VA-19-00002

ZONING VARIANCE APPLICATION

RE: VA-19-00002 and SI-19-00002 – Deemed Incomplete and Request for Additional Information

Drawing file: VA-19-00002 Thorp Sign / VA-19-00002 Thorp Sign Site Survey Sheet 1.pdf

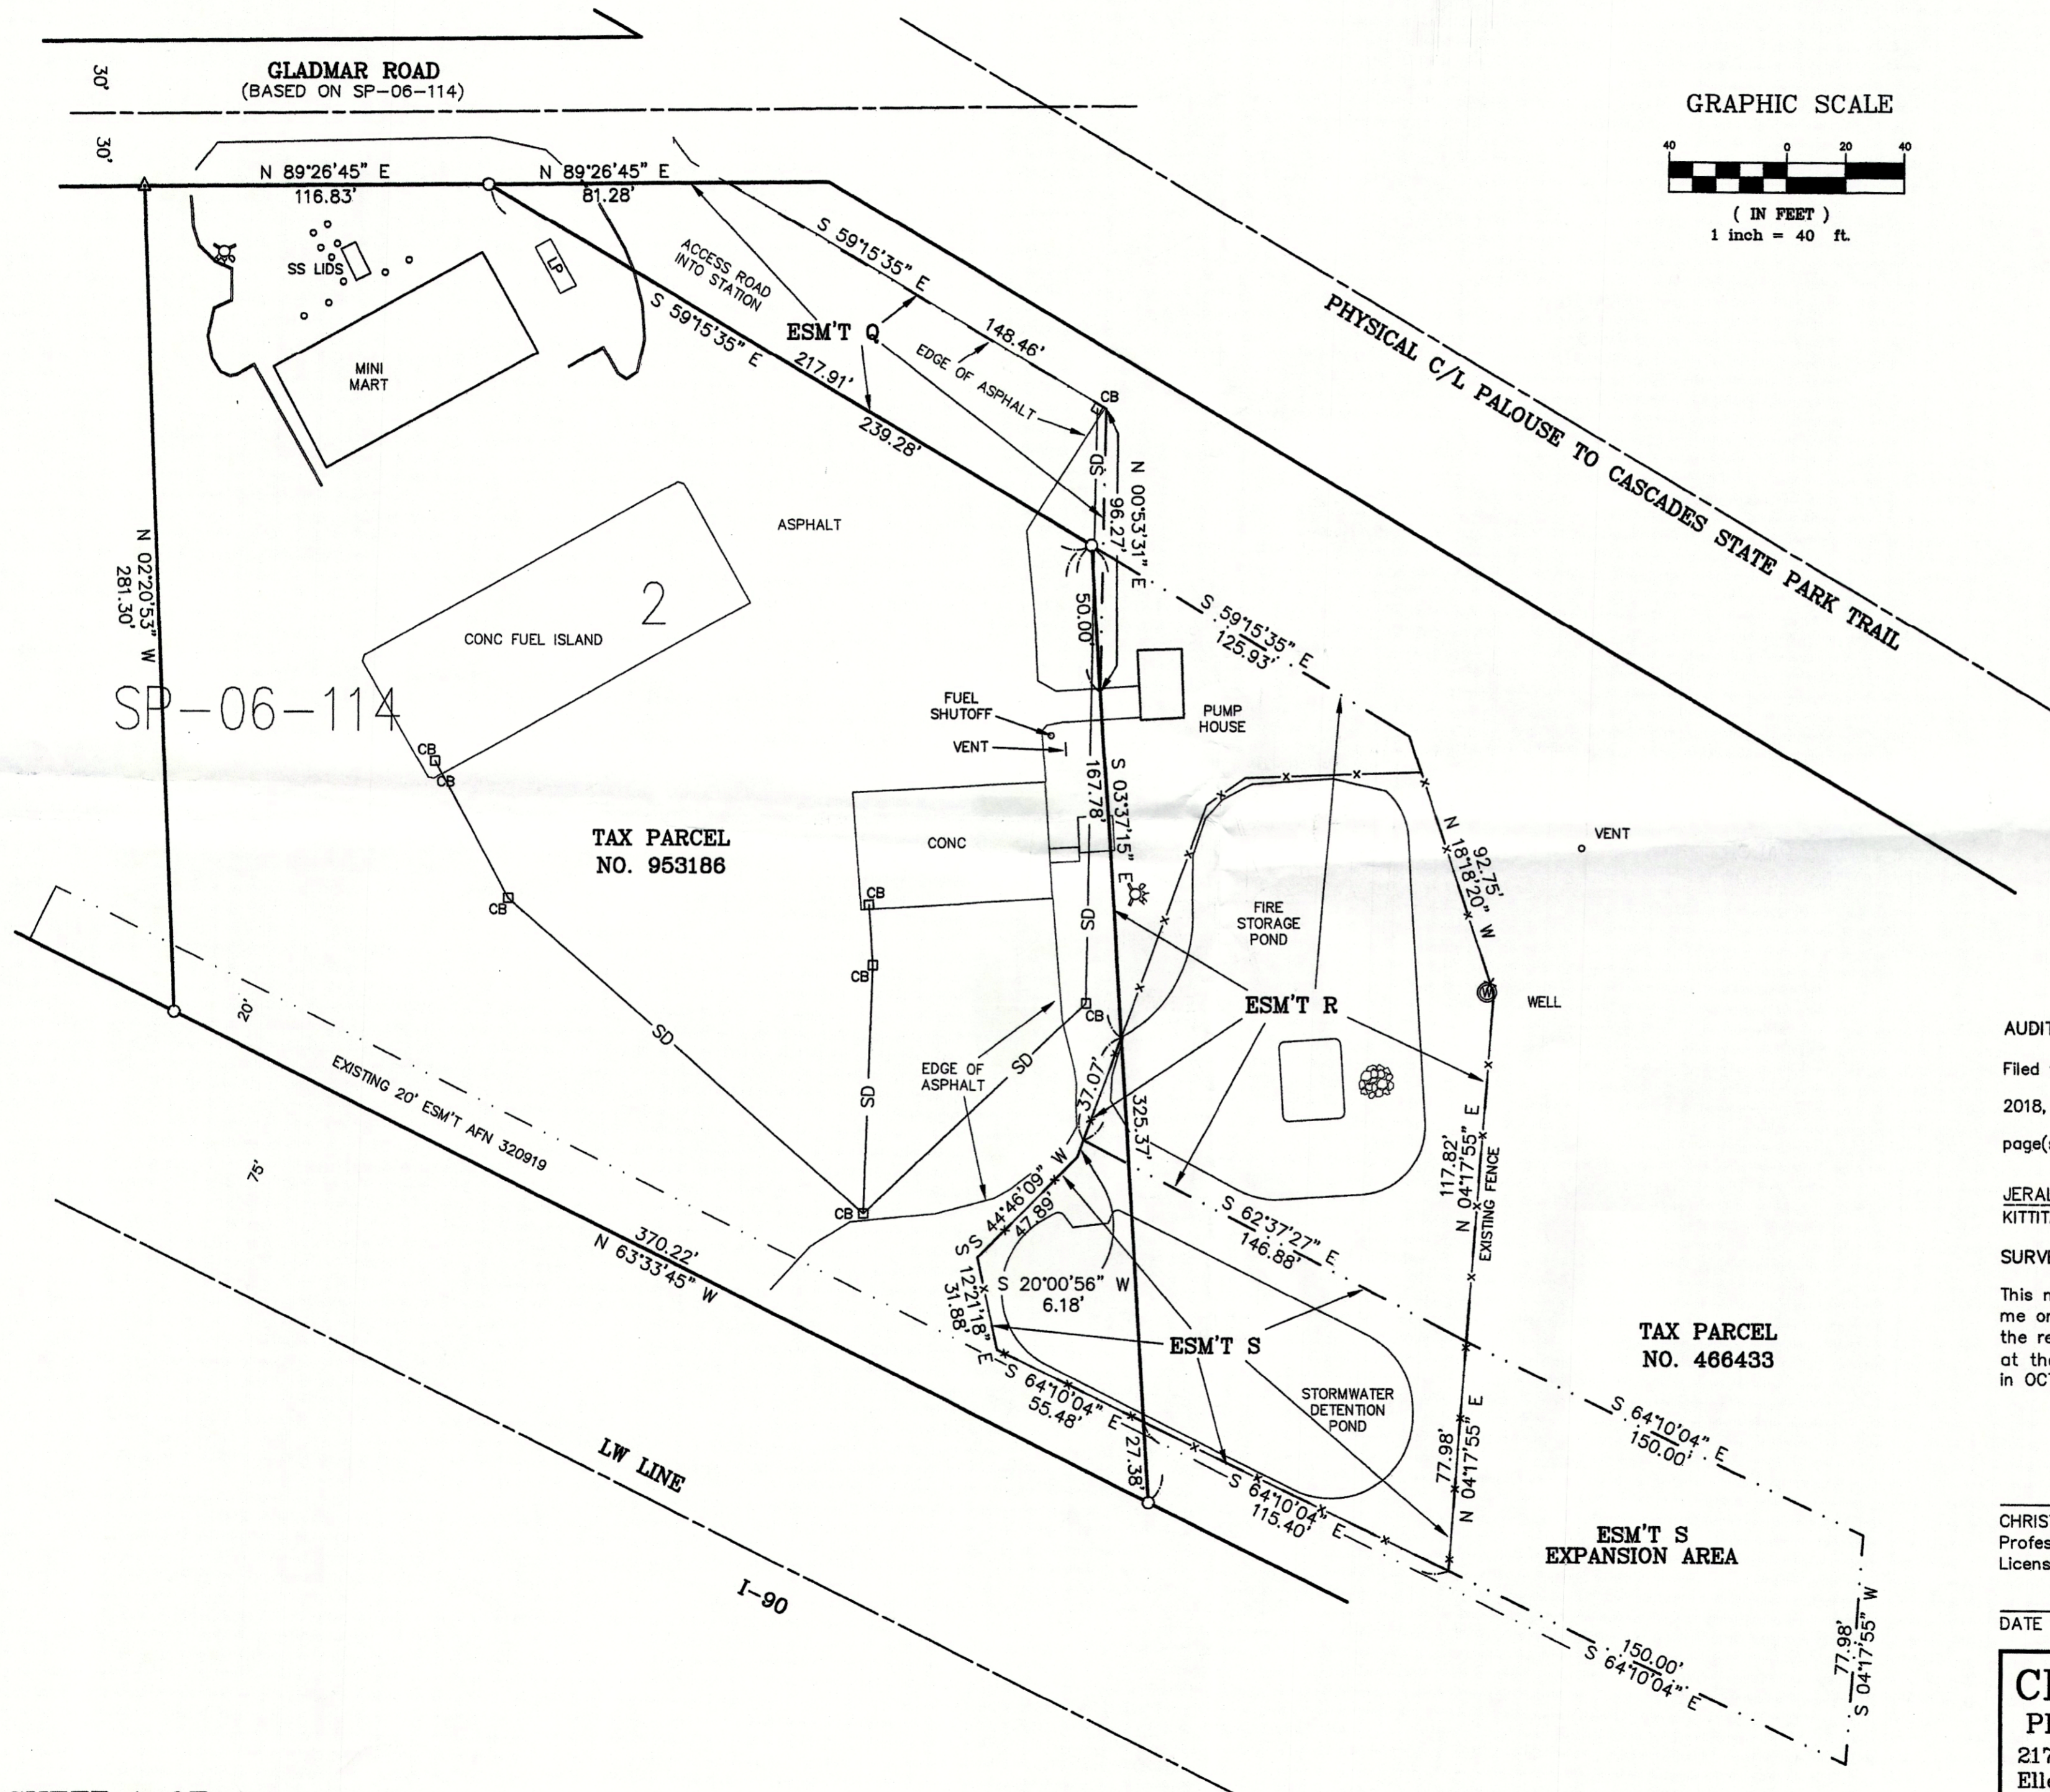
- C) The application does not indicate the likely fall radius of the proposed sign, nor does it show the dimensions from property lines to the sign. In order to continue processing of the application, revisions to the site plan are needed, indicating where the sign is likely to fall in the case of structural failure and collapse, and also show the dimensions from the edge of the sign post to the north, east, and southern property edges; in order to determine whether “*the granting of such variance will not be materially detrimental to the public welfare or injurious to property in the vicinity or district in which the property is located*” as required by item # 3 above.

1. A revised narrative detailing how the application meets the criteria for KCC 17.84.010(1), (2) and (3).
2. Additional information as to plans for the existing sign on the I-90 frontage.
3. A revision to the site plan depicting the likely fall radius in case of structural failure prepared and stamped by an engineer licensed in the State of Washington.
4. A revision to the site plan depicting the dimension from the base of the sign to the north, east, and south property lines.

The height of the sign has been reduced from 120' to 100' to 87.5'

Placement is on the applicant's property within the fall zone radius. Please note exhibit attached. We will comply with requirements that only one sign allowed per frontage. The current sign will be replaced and removed and not be relocated and thus avoid another variance request.

Also please note that in the direction and in consideration of the NW winds the fall zone to NW is totally fenced and will deny any pedestrian access. The NW fall zone in between fire storage pond and stormwater detention ponds and non-business area.
